## WEST SUSSEX COUNTY COUNCIL CONSULTATION

<b>TO:</b>	Arun District Council FAO: Hebe Smith
<b>FROM:</b>	WSCC – Highways Authority
<b>DATE:</b>	22 January 2025
<b>LOCATION:</b>	110 Downs Way, Littlehampton, BN16 1AF
<b>SUBJECT:</b>	A/2/25/PL Demolition of existing detached garage and creation of 1 No new semi-detached dwelling with associated landscaping and parking. This application is in CIL Zone 4 and is CIL Liable as a new dwelling.
<b>DATE OF SITE VISIT:</b>	n/a
<b>RECOMMENDATION:</b>	Advice

PROPOSED SITE PLAN

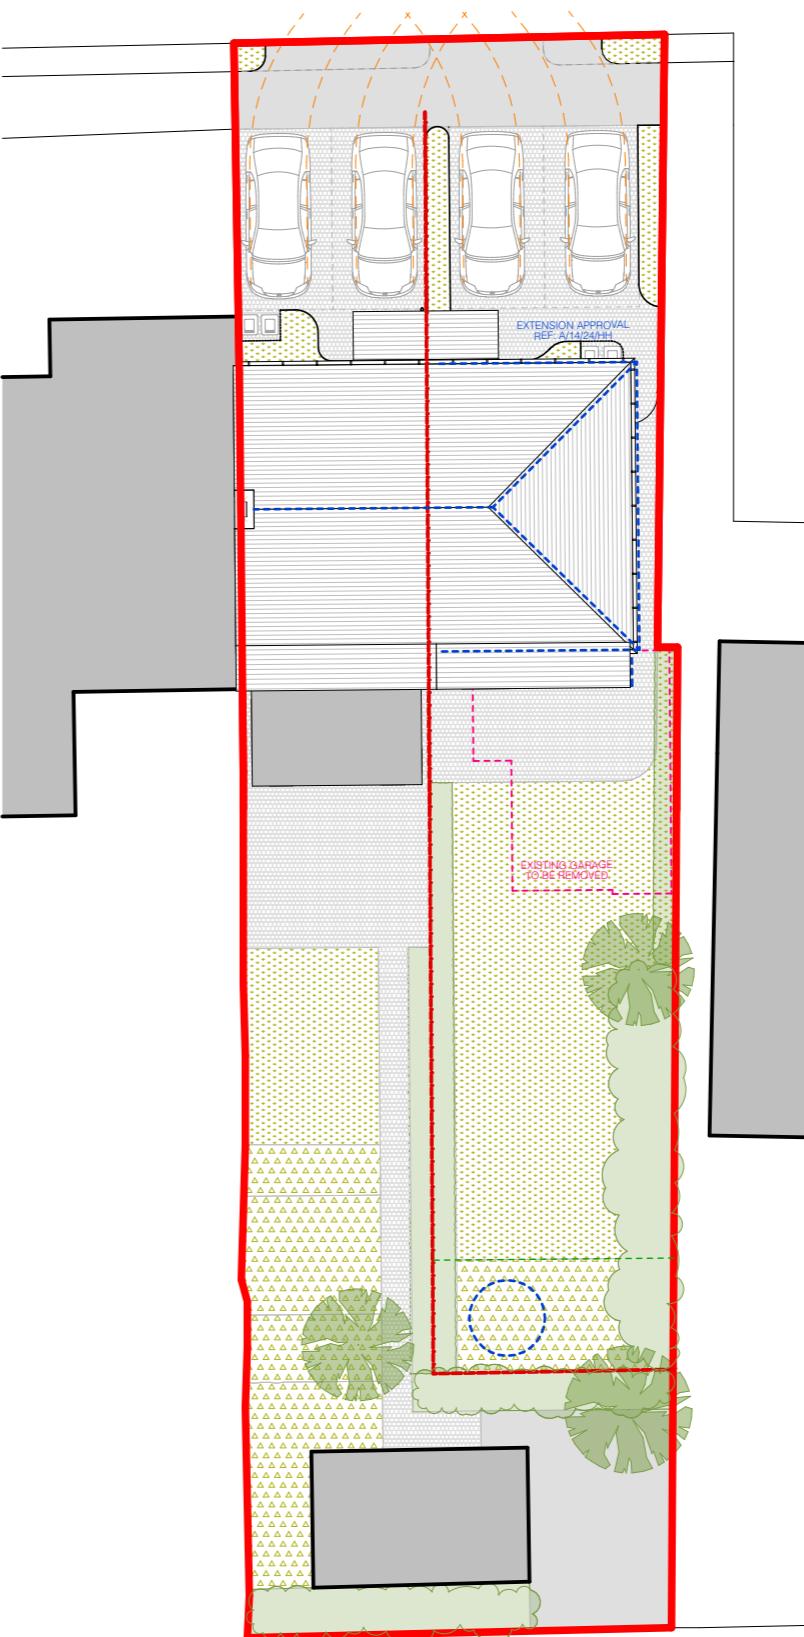
The applicant proposes widening the existing vehicular access to create access for the existing and proposed dwellings on to Downs Way. The proposed access works will be subject to a licence obtained through the local Highway Area Office and constructed to a specification agreed with the local Highway Area Engineer.

The applicant proposes four car parking spaces for this development, which meets the Arun Car Parking Standards for development of this size in this location. Therefore, the LHA is satisfied with the proposed level of parking provision.

From inspection of the plans, the proposed parking bays are suitably sized. On-site turning does not appear achievable, so cars may have to exit the site in reverse gear. However, this is not anticipated to give rise to an adverse highway safety impact, owing to good forward visibility in this location. Neighbouring properties operate similar access arrangements with no known highway safety concerns.

No part of the development shall be first occupied until the car parking has been constructed in accordance with the approved site plan. These spaces shall thereafter be retained at all times for their designated purpose.
